**From:** John Barkham [REDACTED]  
**Sent:** 08 October 2020 14:02  
**To:** Daun Johnson <Daun.Johnson@arun.gov.uk>  
**Cc:** Planning.Responses <Planning.Responses@arun.gov.uk>  
**Subject:** FG/123/20/PL

Thank you for your letter of today with request for further information in order to validate this application.

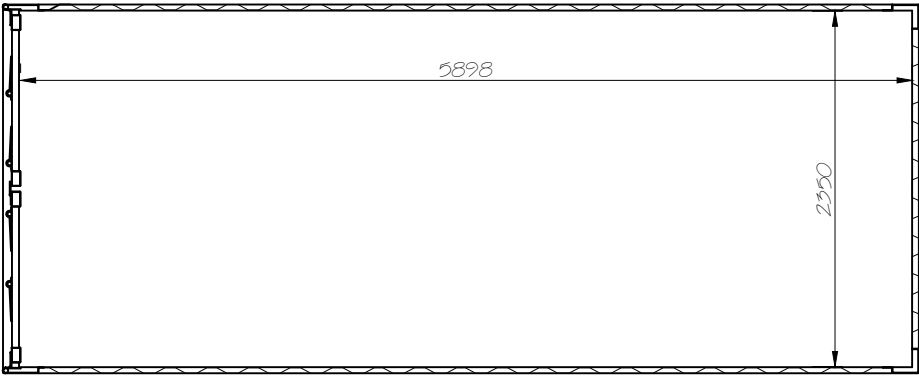
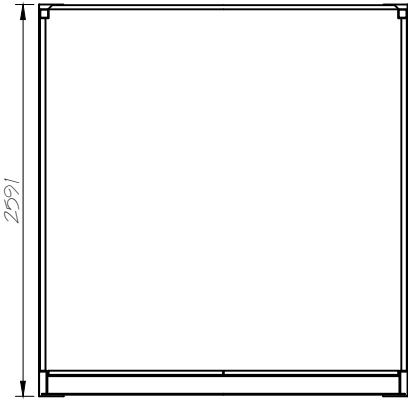
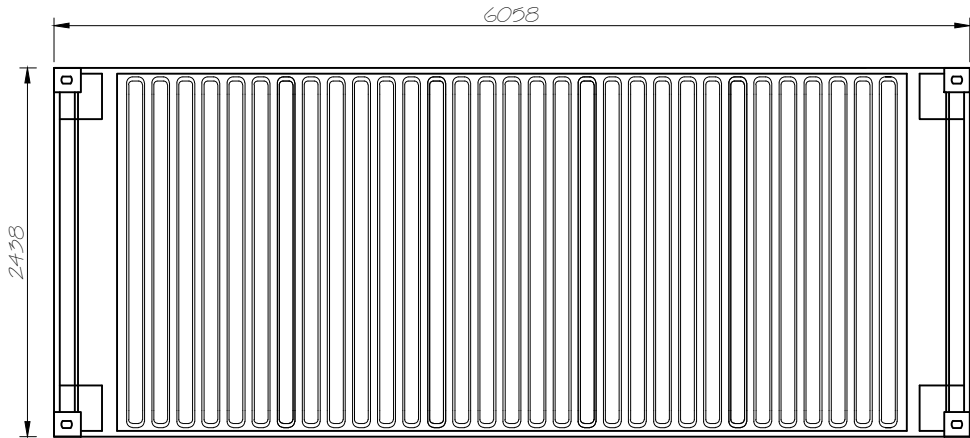
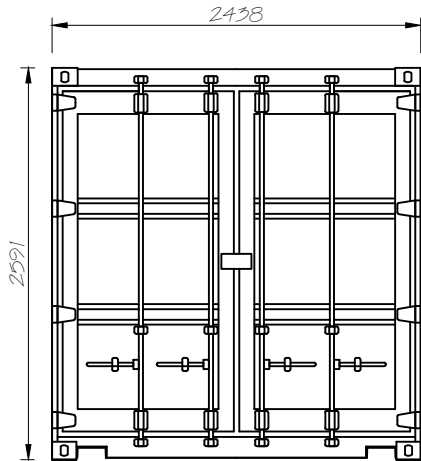
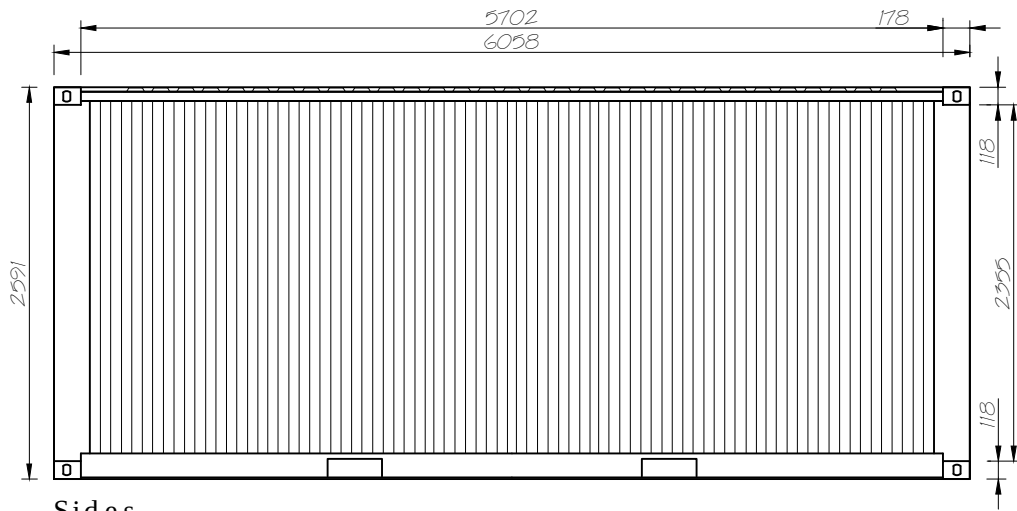
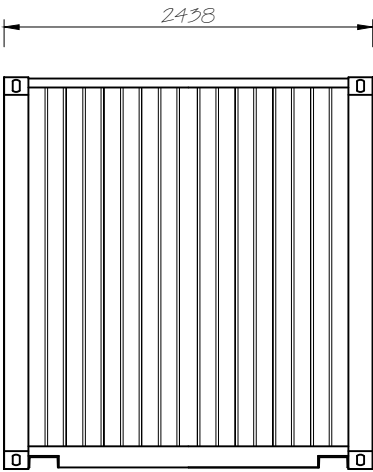
I would refer you to previously supplied drawing 5320-5A. This drawing of a standard 20' container includes annotated dimensions in metric only.

DWG NO	REV
5320-2	C

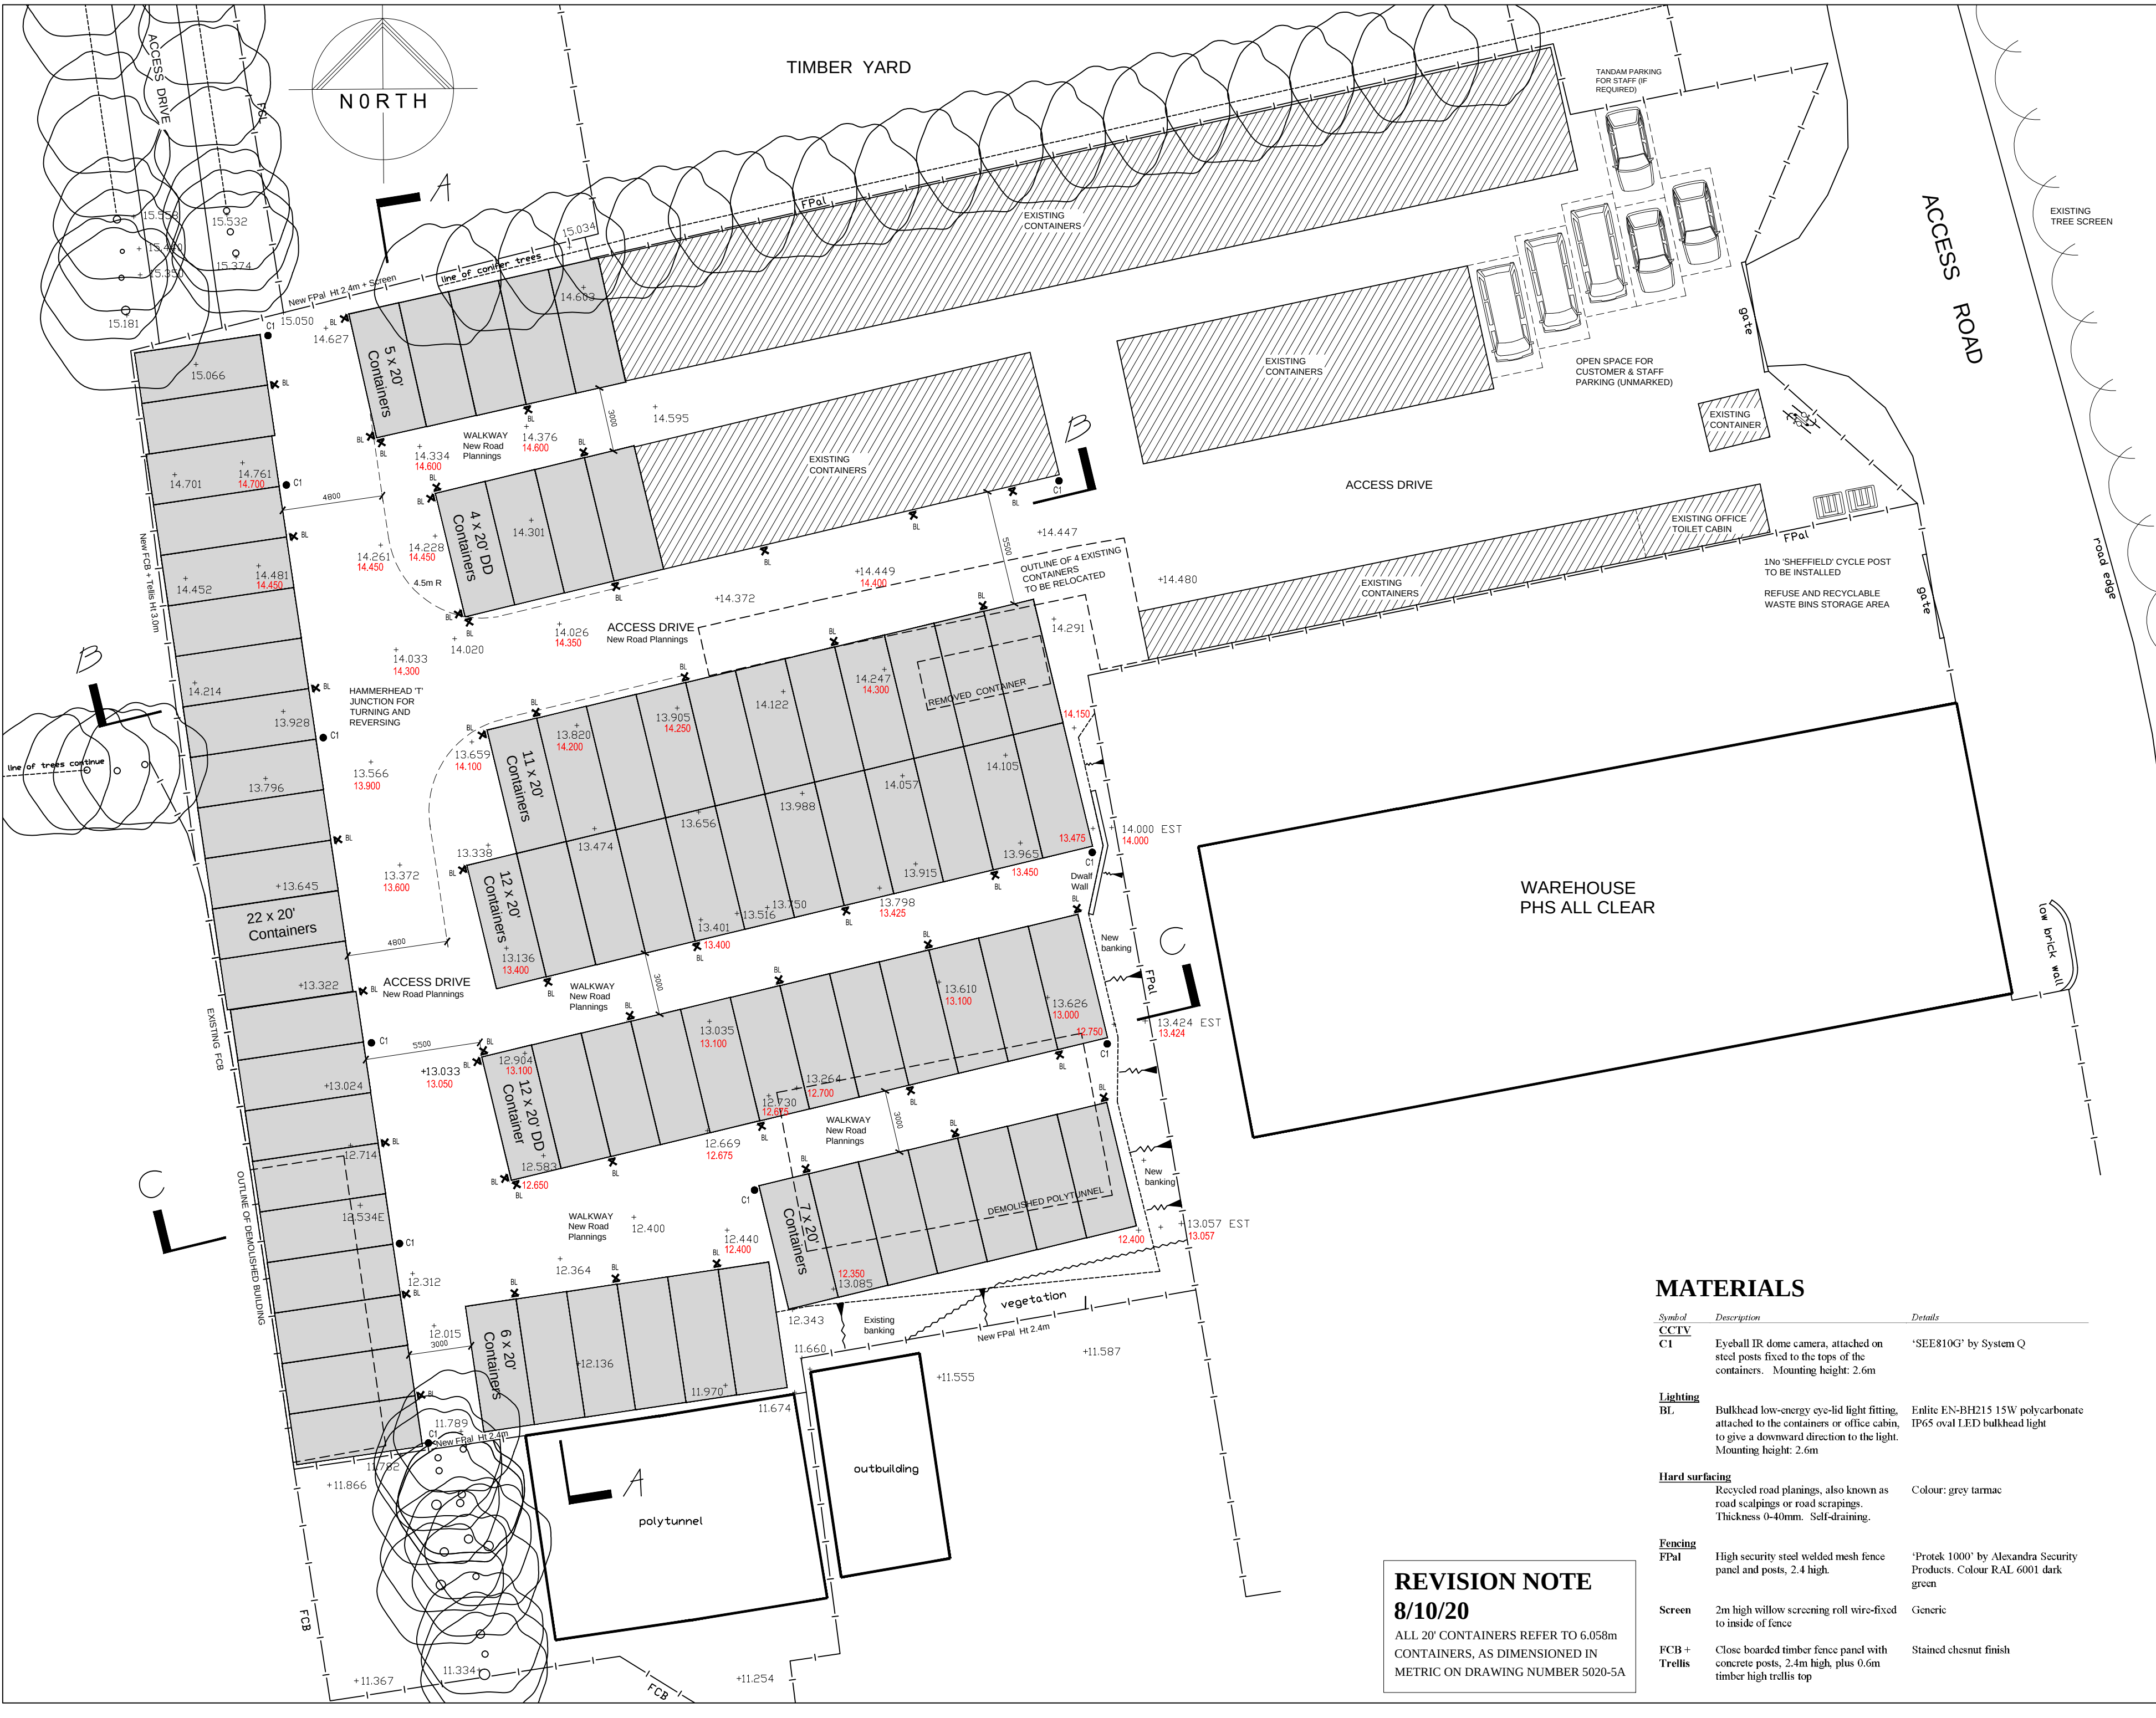
All dimensions stated on drawing 5320-2A have been annotated in metric.

I therefore assume you are seeking clarification as to the use of the term: 20' to describe a standard shipping container. This is the convention in the world of containers, which follows American practice of using imperial terms. Also, 20' falls off the tongue easier than saying a six point zero five eight container.

The legend states that 'MD' is a multi-door container with side opening doors. The 'x4' references four doors. However, I have now changed this container to a standard 20' container on the attached revised drawing.

However, I have now added an additional revision note on the attached amended drawing 5320-2B to further clarify the above.
